14 February, 2018

RE: CASE # 18-06-0370P. RESPONSE TO FEMA SUMMARY OF ADDITIONAL DATA REQUIRED TO SUPPORT A LETTER OF MAP REVISION, DATED 11/30/17.

Weston received a *Summary of Additional Data Required to Support a Letter of Map Revision* in a letter from FEMA dated November 30, 2017. Our responses and the additional data that was requested and are provided below:

3840 COMMONS AVE. NE ALBUQUERQUE NEW MEXICO CYPRESS DRIVE STORM DRAIN PROJECT LOMR APPLICATION POST-PROJECT CONDITIONS WORK MAP

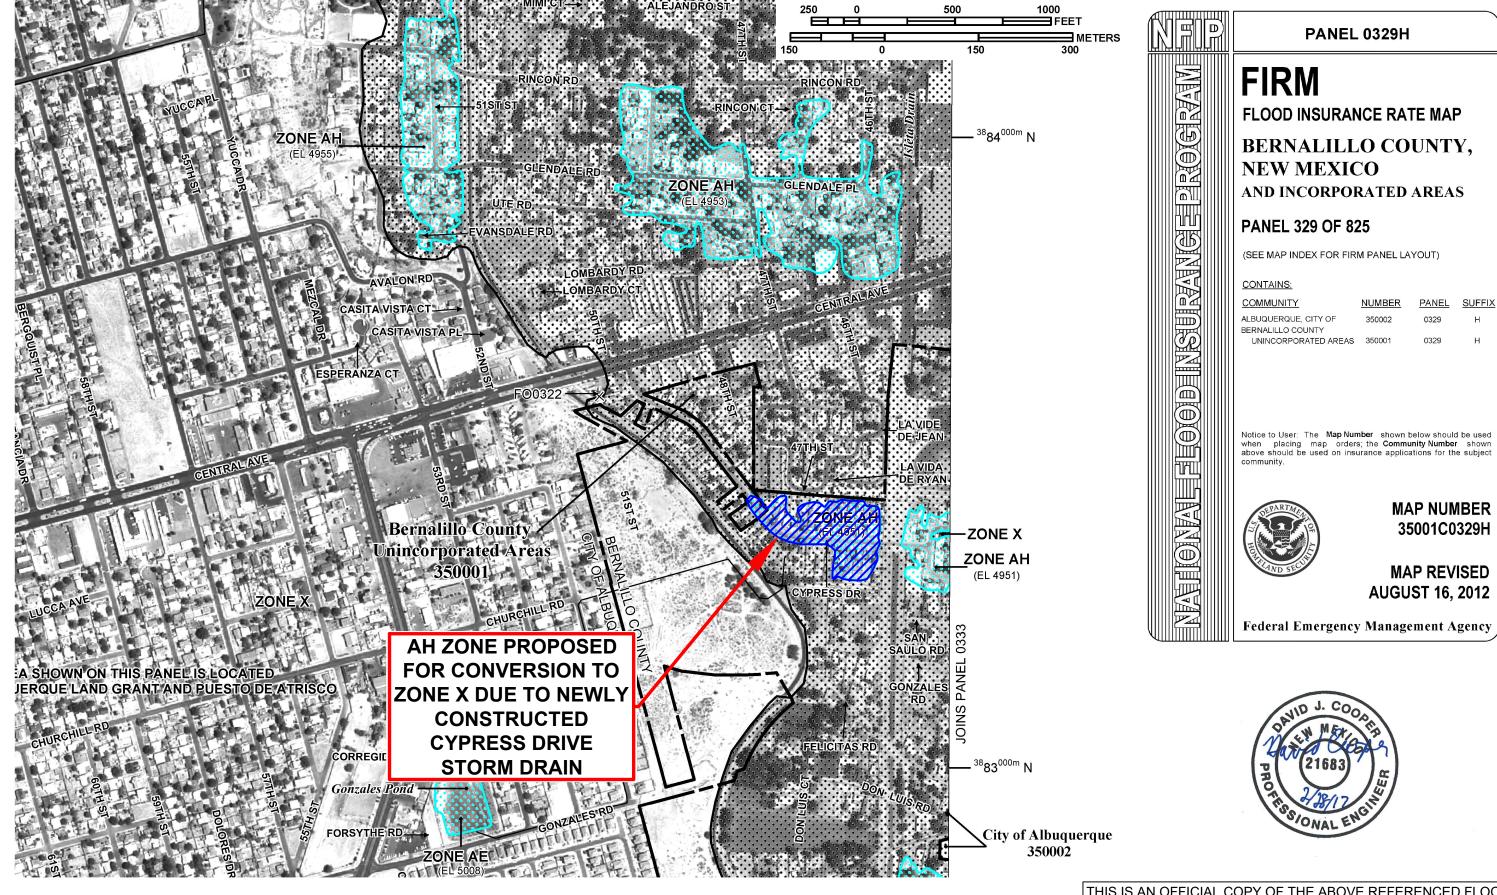
3. *The submitted topographic work map entitled "Post-Project Conditions Work Map," prepared by Weston Solutions, Inc., dated February 28, 2017, does not provide essential information required to complete our review of this request. Please submit a revised topographic work map, certified by a registered Professional Engineer that shows all applicable items listed in Section C of Application/Certification Form 2, entitled "Riverine Hydrology & Hydraulics Form," including the following information:*
- a. *Boundary delineations of the post-project conditions 1-percent-annual-chance (base) floodplain;*
 - b. *Logical tie-ins between the revised and effective flood hazard boundary delineations; and*
 - c. *Topographic contour information used for the boundary delineations of the base floodplain and*
 - d. *0.2-percent-annual-chance floodplain.*

4. *The above-referenced topographic work map was submitted in hard copy format only. Please provide digital Computer-Aided Design (CAD) or Geographic Information System (GIS) data for the above-referenced topographic work map. Please ensure the digital data are spatially referenced and cite what projection (coordinate system, example: Universal Transverse Mercator [UTM]/State Plane) was used, so that the data may be used for accurate mapping.*

RESPONSE TO COMMENT 3: The *Post-Project Conditions Work Map* has been modified to provide the requested information. The revised work map, certified by Weston's New Mexico Professional Engineer, includes text explaining that Zone AH is removed because the storm drain conveys all of the 1-percent annual chance storm without overtopping the inlets, leaving no boundary delineations, no logical tie-ins, and no need for topography that supports the delineations. Please see Attachment B to this letter and on CD.

RESPONSE TO COMMENT 4: The LOMR Work Map, including the relevant information requested above, is attached to this letter as Attachment B and is included on the CD in Autodesk Civil 3D 2016 format as Attachment B.
